22/03033/F The Stables, Wendlebury OX25 2PR

Objection to the above application, specifically regarding the 'Agent - Additional supporting letter 6.12.22' written by Emma Wagland of Edgars in Witney and put on the planning portal on 21/12/2022

PROPOSED ELEVATIONS

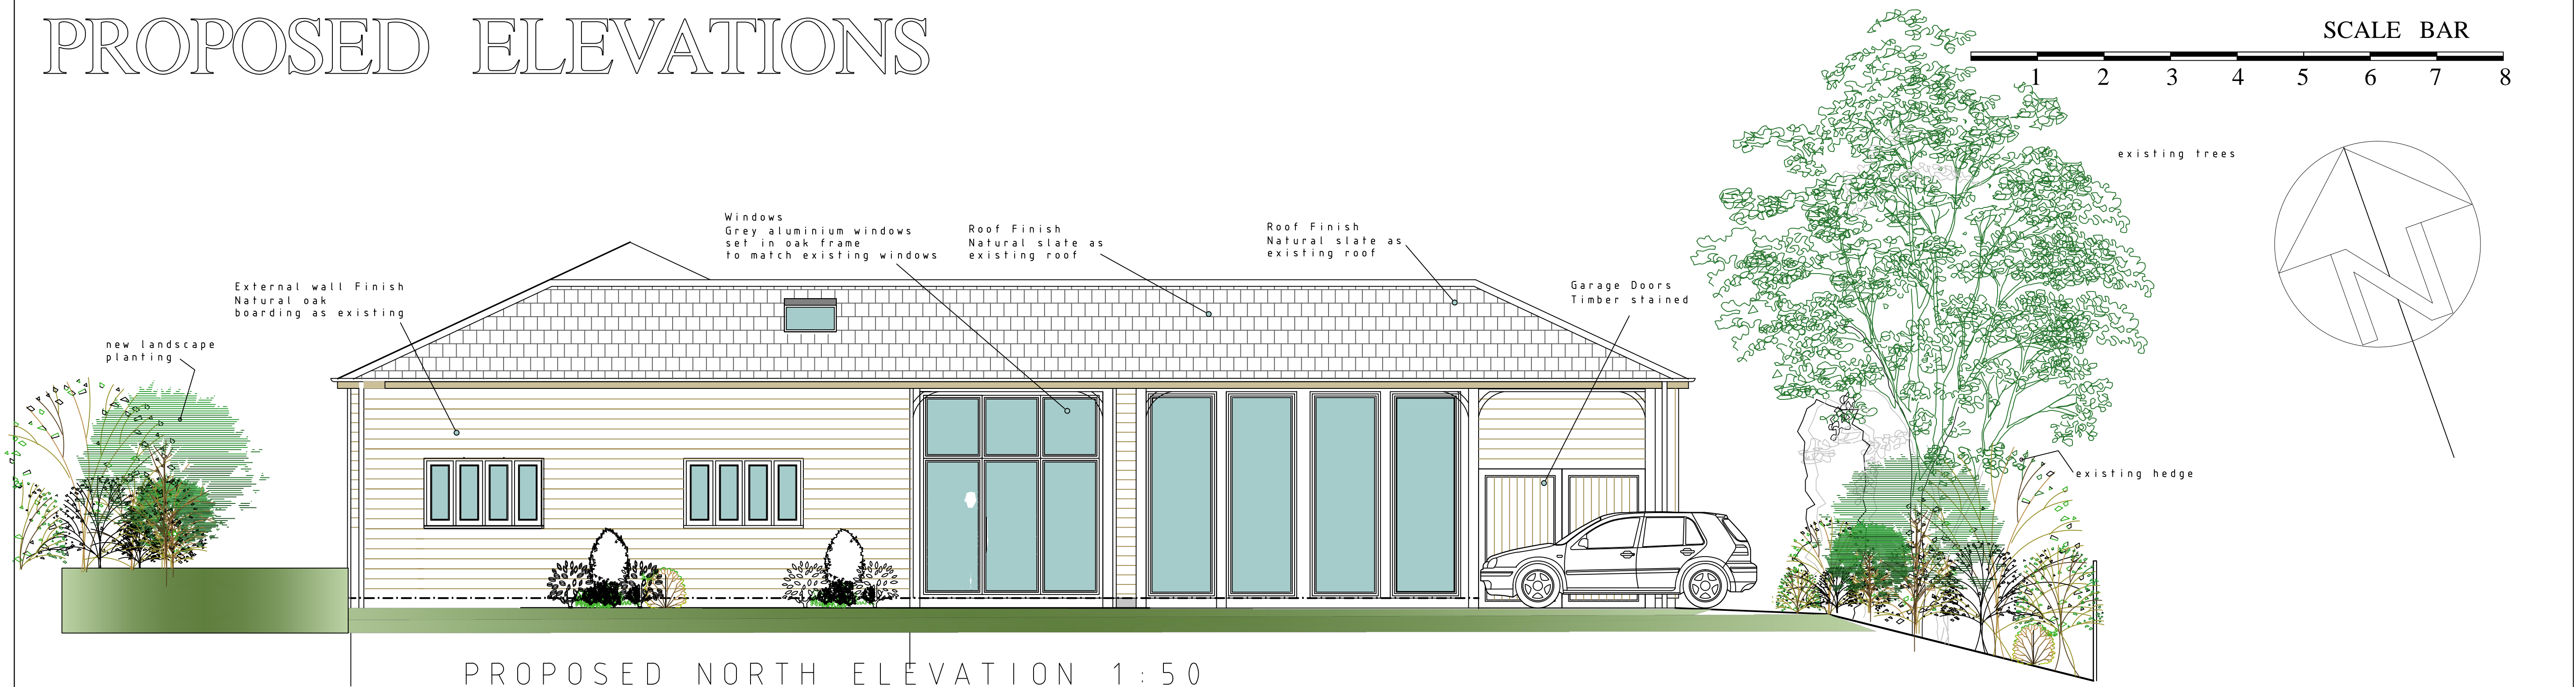
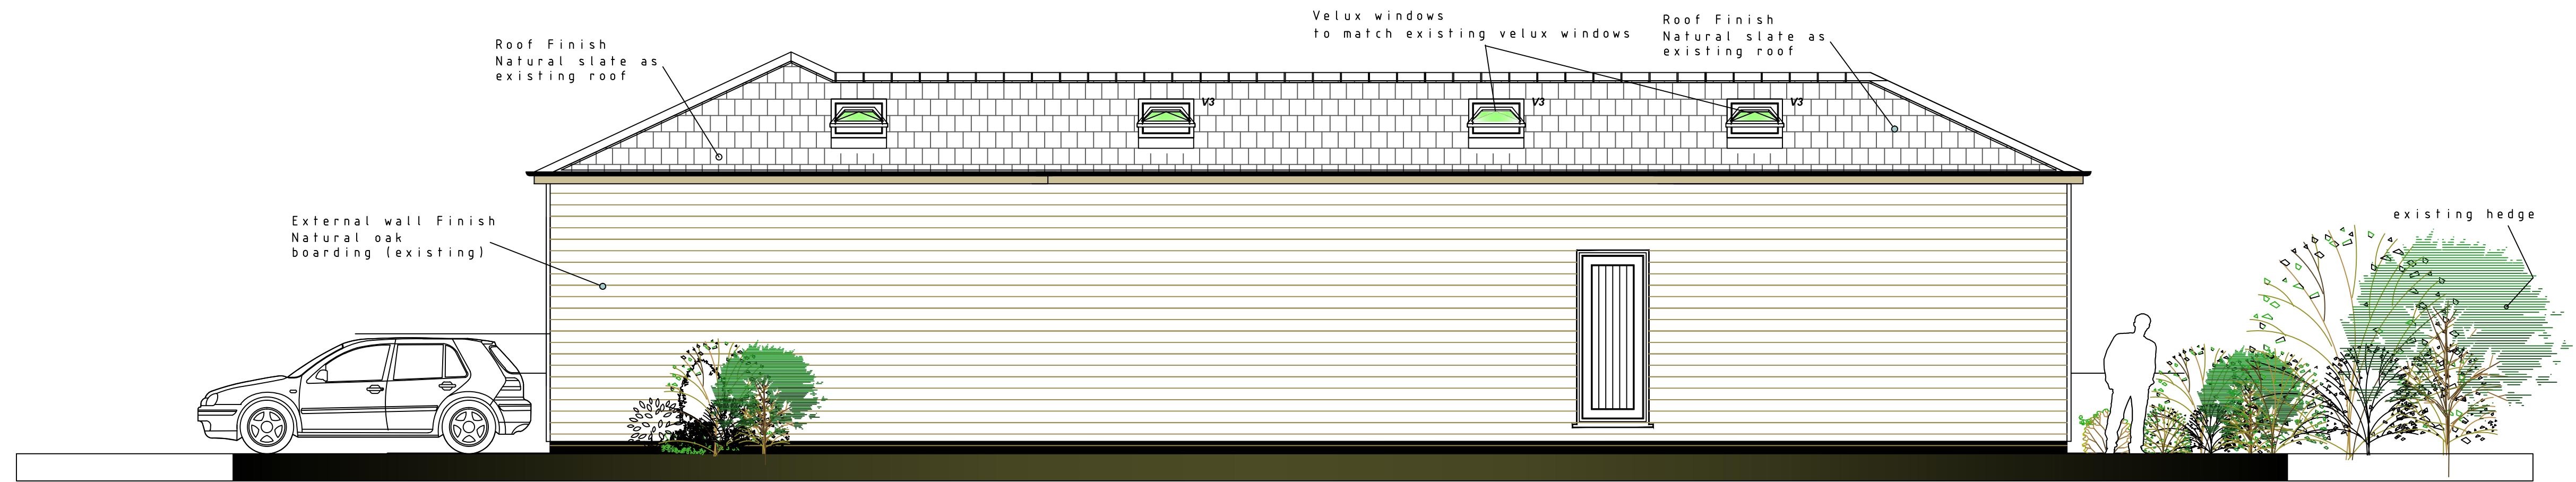
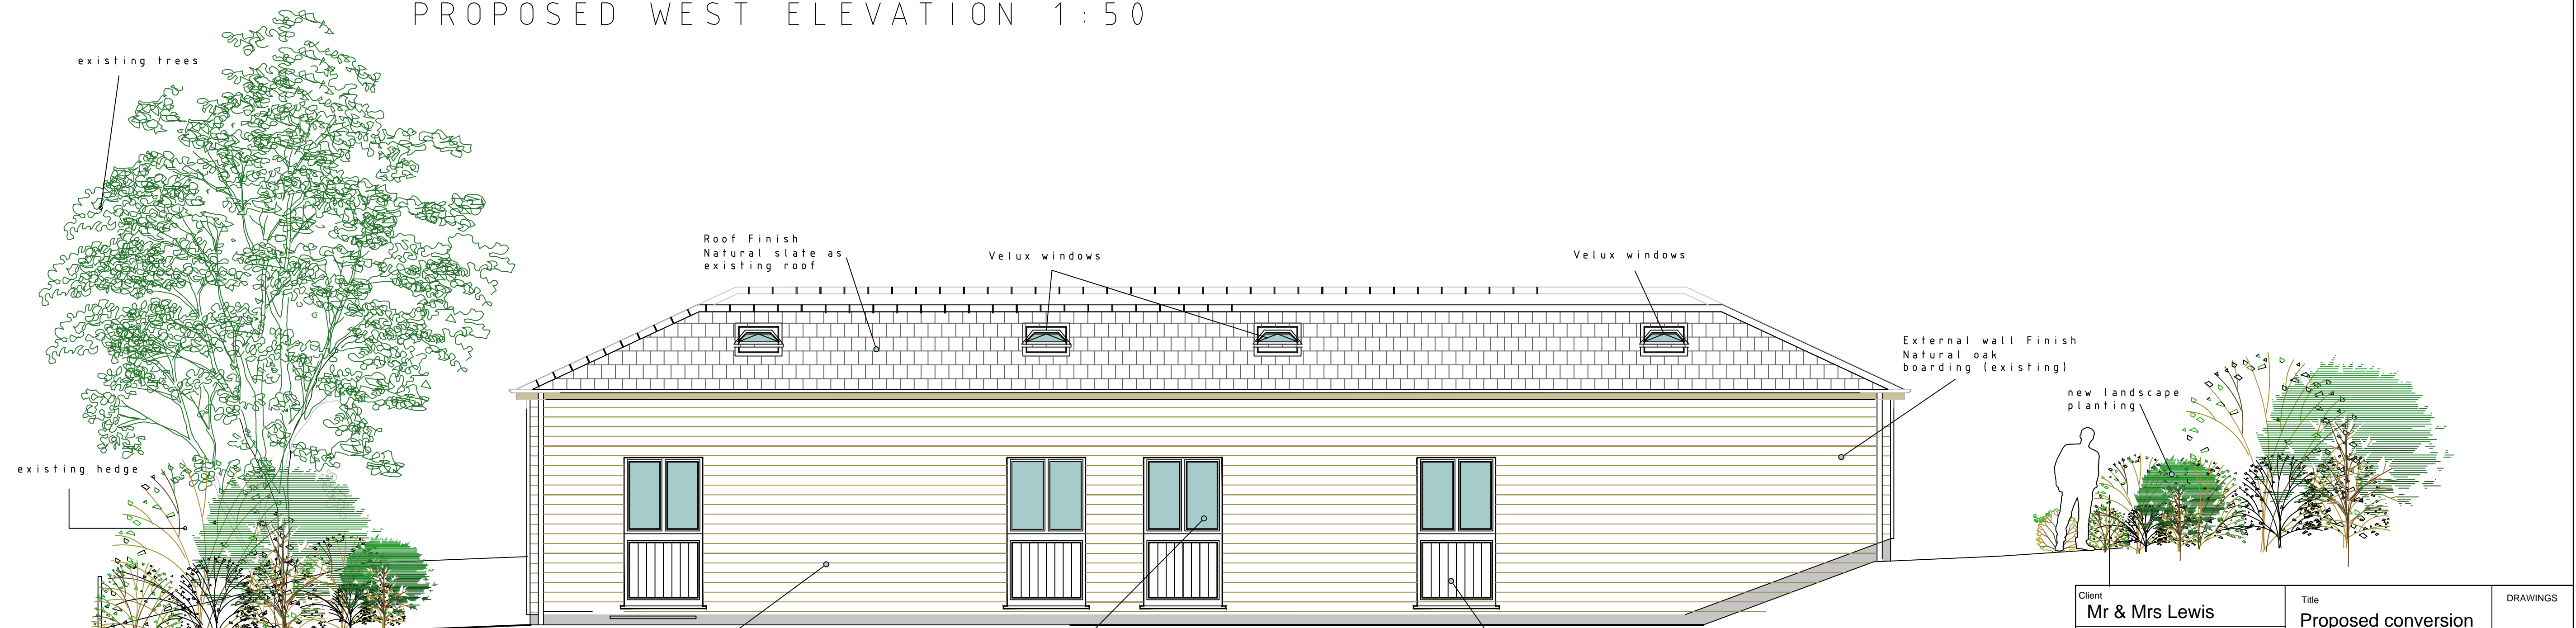
Proposed West Elevation

This elevation proposes a door to the utility room.

The proposed plans show no path or access to this door and there is no mention of this in the application. The land by the proposed utility room door slopes steeply down towards the two neighbouring properties of The Old Dairy and The Old Granary. The unavoidable issue is that the current stables stand on land that is at least 2 metres higher than The Old Dairy and The Old Granary and therefore any openings in the proposed property on that elevation in particular, overlook the gardens and into their grounds and windows.

This utility room door will become a frequently used back door to the house as the applicant has a horse, dogs and a dog walking business. It is highly likely that the utility room will be the place where dogs and footwear/coats are kept. Constant use of this back door, will cause a huge impact on the two neighbouring properties. It will make the gardens and houses of The Old Dairy and The Old Granary extremely public.

Currently, access to the proposed utility room door is via a sloping earth bank. In the application it is proposed that the rubbish bins will be kept by this door. Cherwell homes have three large wheelie bins. In order to enable people to move the bins and to walk to the proposed utility room door, a path will have to be constructed. This is not mentioned in the application. As well as being intrusive to the two neighbouring properties, the construction of a flat path will add further hard standing. Water from the stables drains downhill towards the neighbouring two properties. There is already an issue with drainage and the top of both gardens are very marshy due to run off from the site above. There has not been any consideration of this issue during the building of the stables. This need to access the proposed utility room door, combined with the proposal to cover the central courtyard of the stables, will lead to more run off from the proposed property.

Proposed Lounge on North Elevation. The lounge is proposed with large opening glass doors along this elevation. The stables is angled so that this elevation is very visible from The Old Dairy. The

height difference makes this unavoidable. Due to the height difference, the whole of the stable is visible to the two neighbouring properties, especially The Old Dairy. Persons walking to the stables are clearly visible above the 6 foot boundary fence and therefore they in turn have completely open views into the garden and rooms of The Old Dairy. The large glass doors proposed for the lounge will compound this even further and make privacy in the garden and main rooms of The Old Dairy impossible.

PROPOSED ROOF PLAN

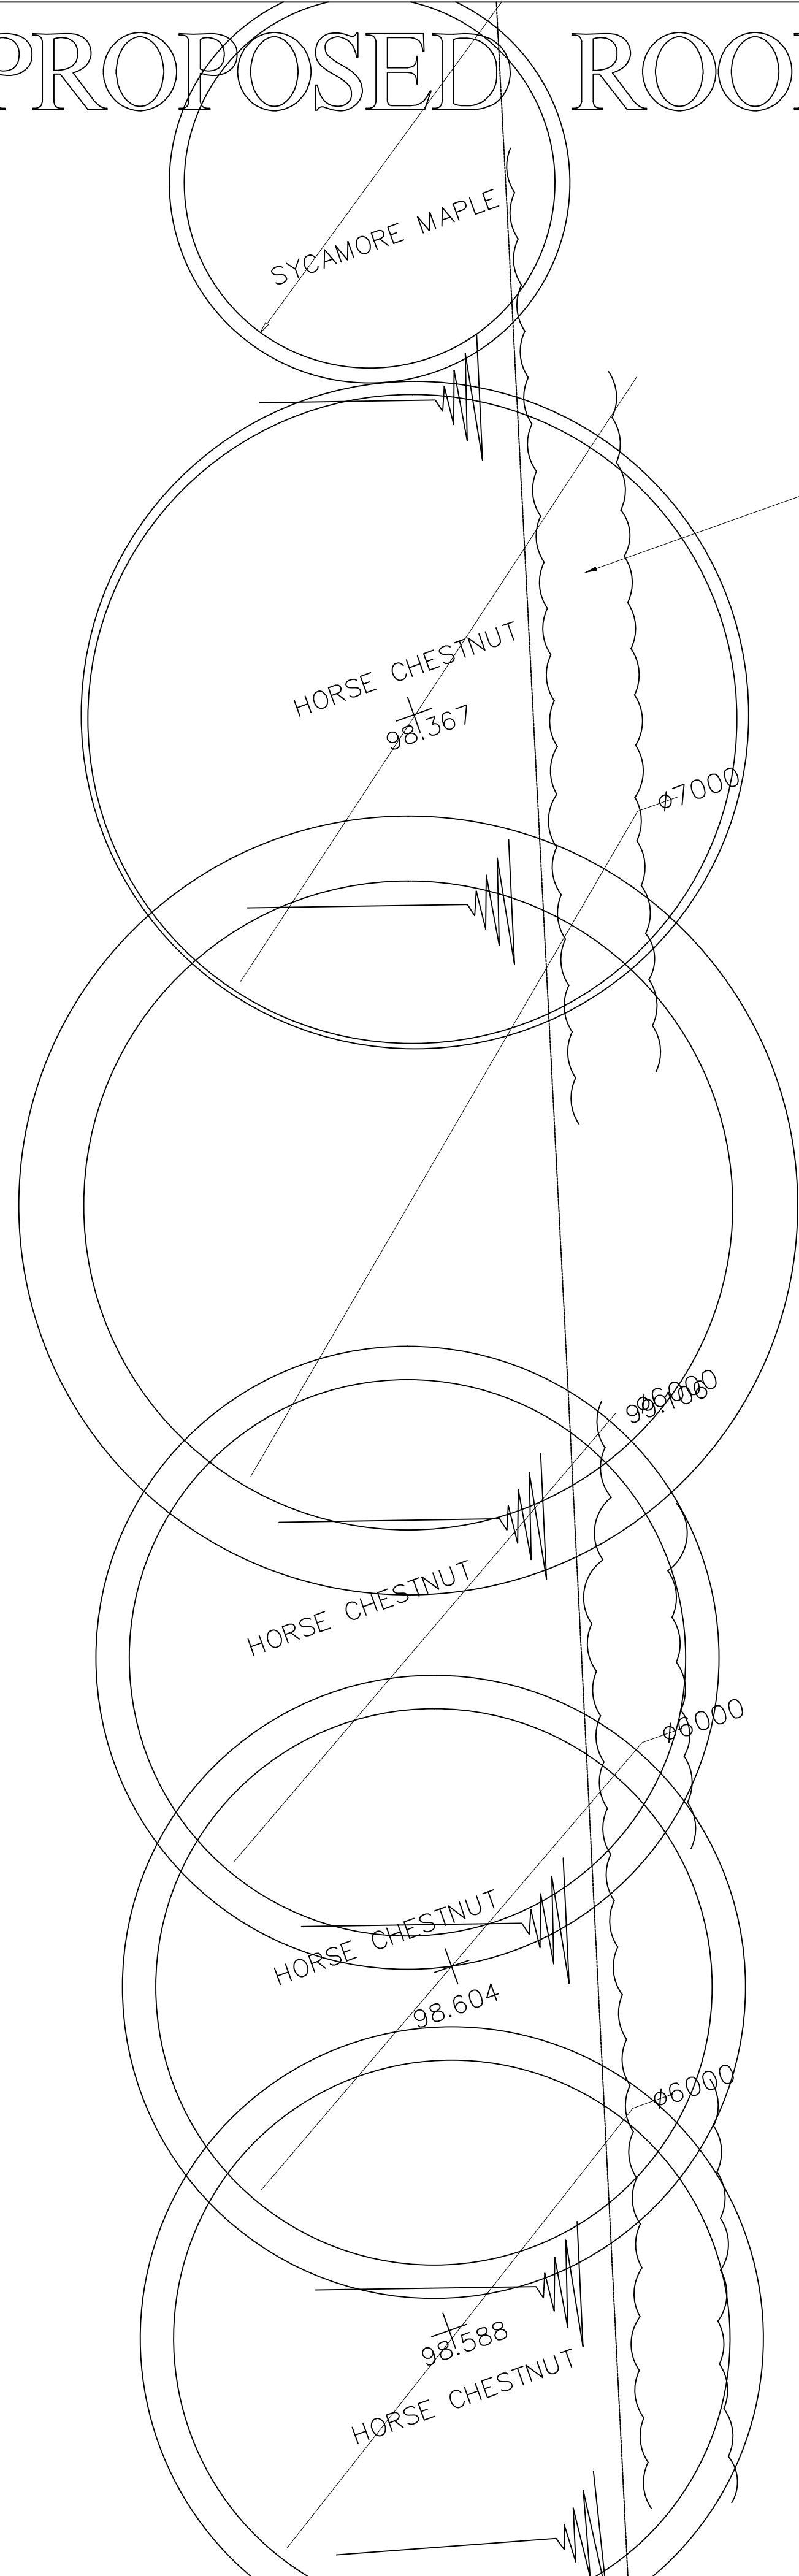
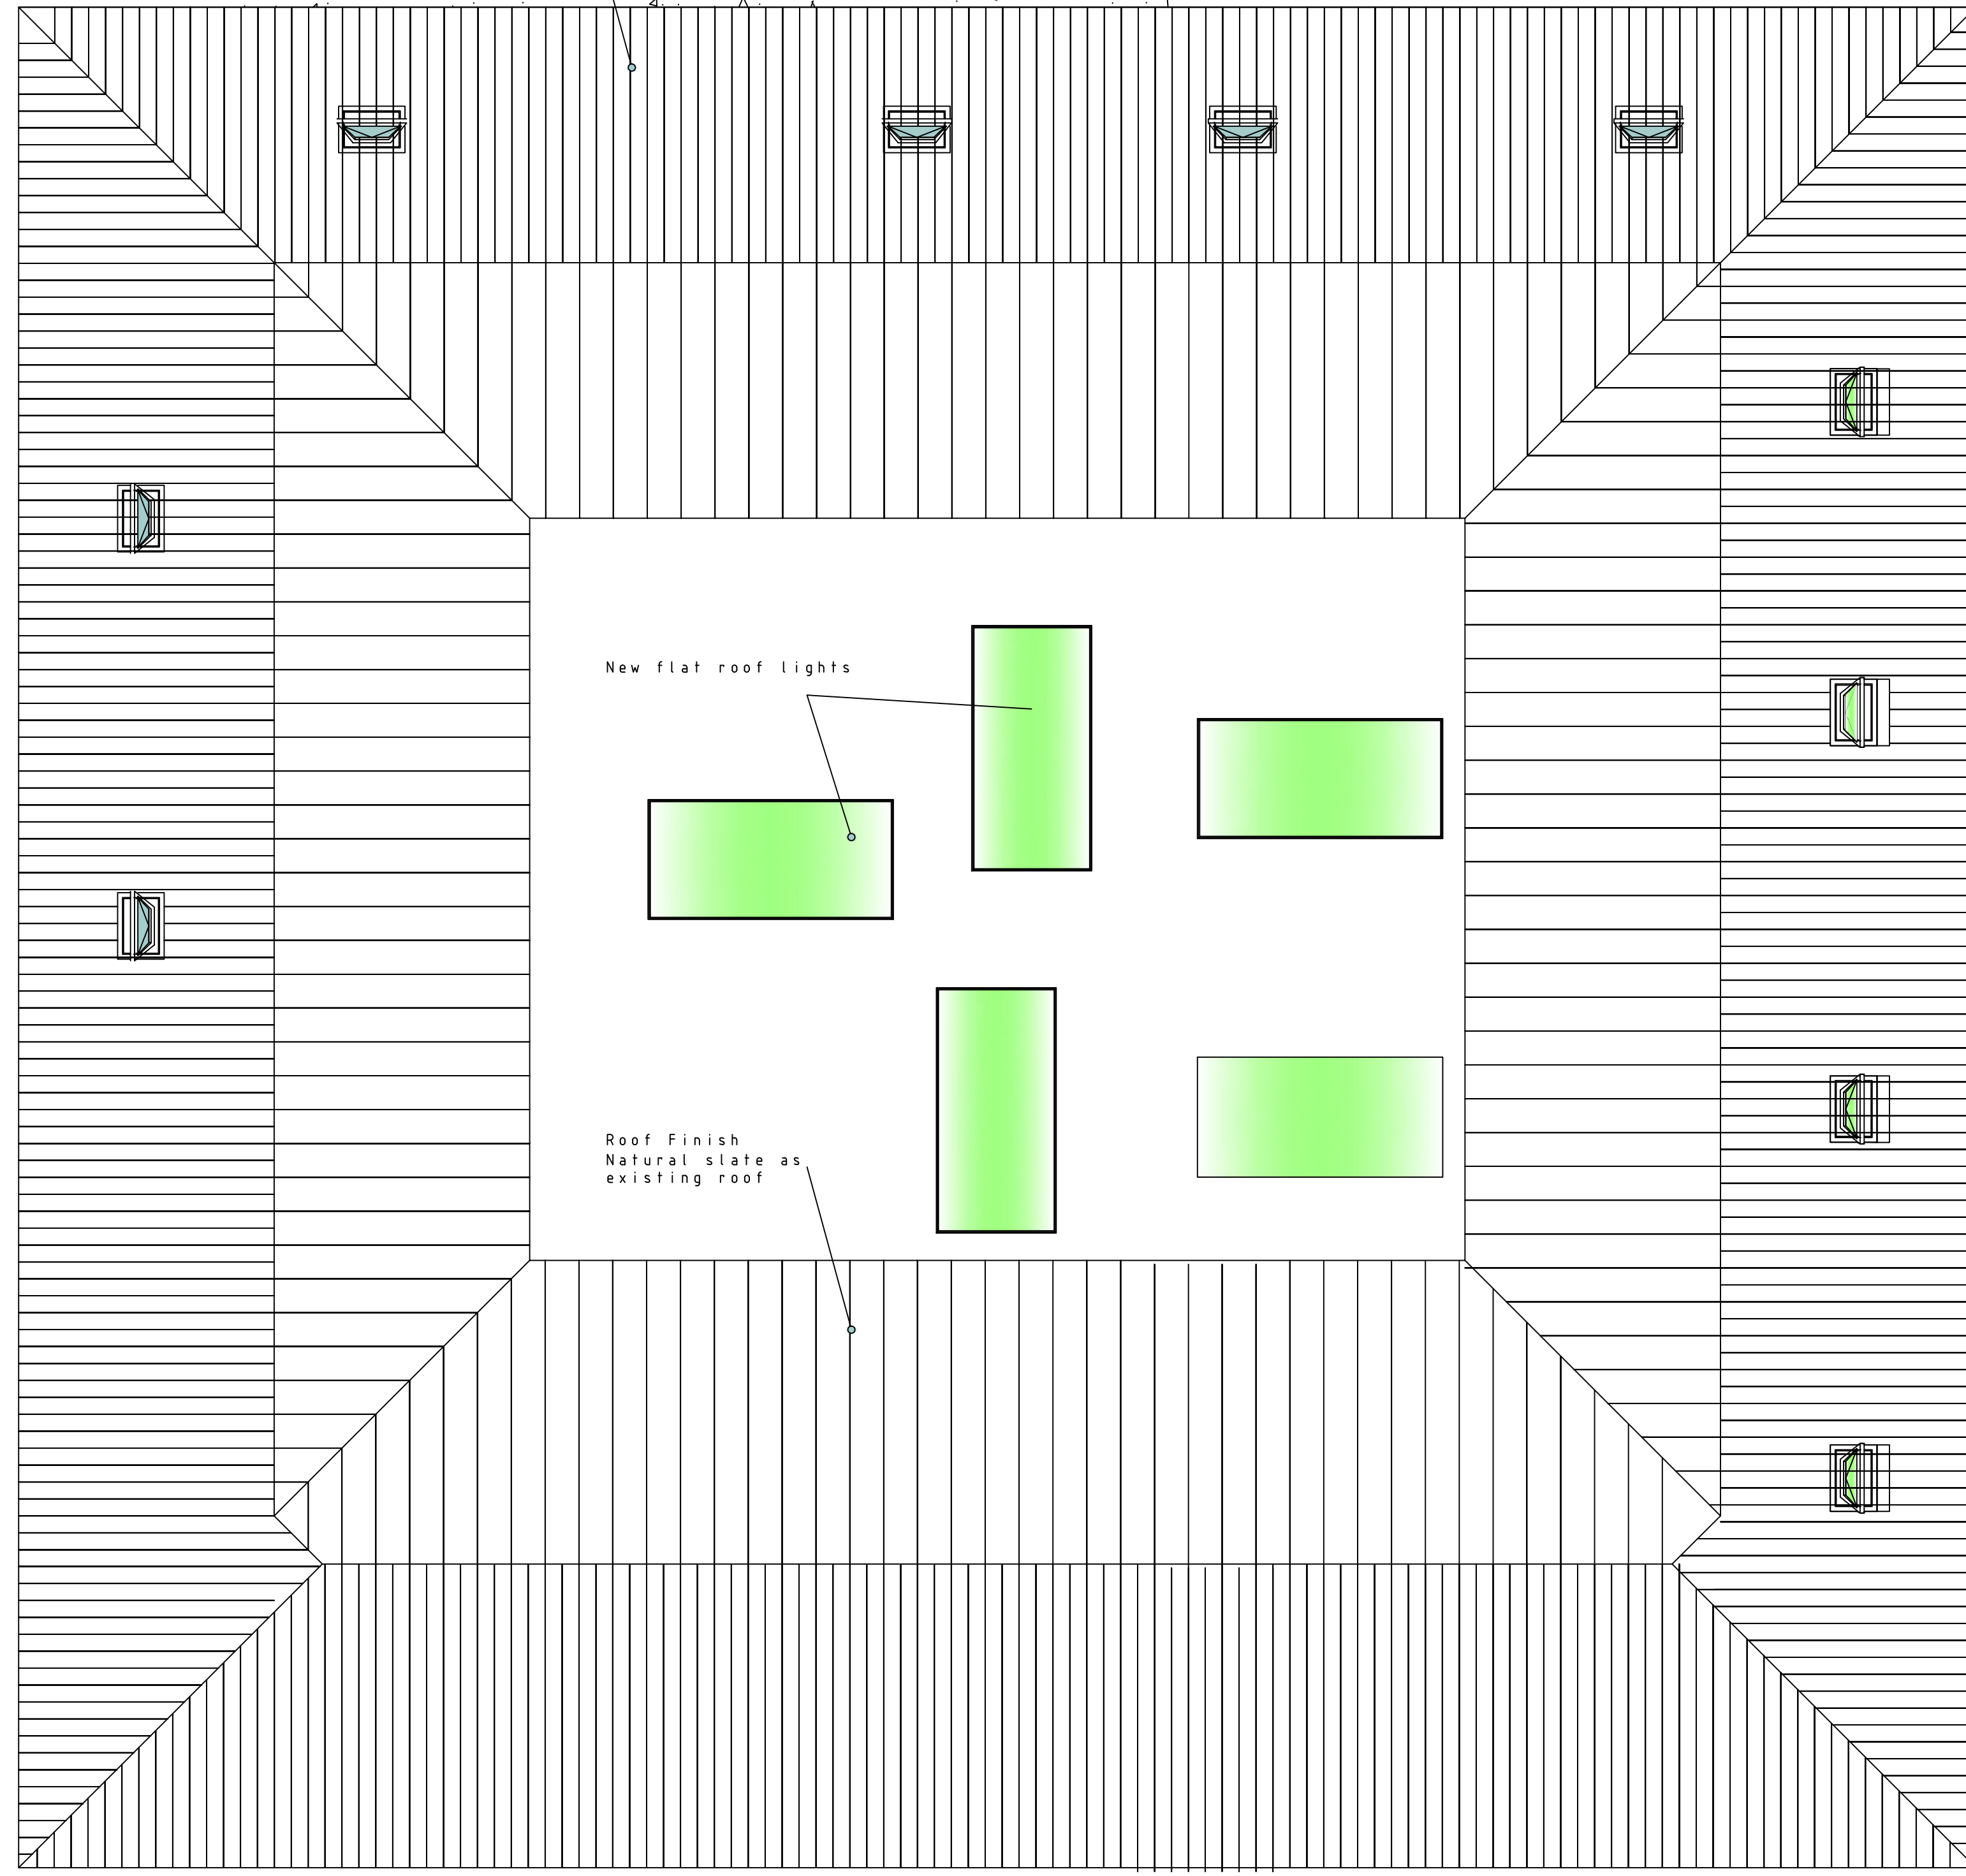
At the moment the stables are not inhabited. The addition of 5 large new flat roof lights, a total of 10 velux windows and the large glass doors will make a huge impact both on wildlife in the wooded area beside the stables and surrounding open land as well as the neighbouring properties.
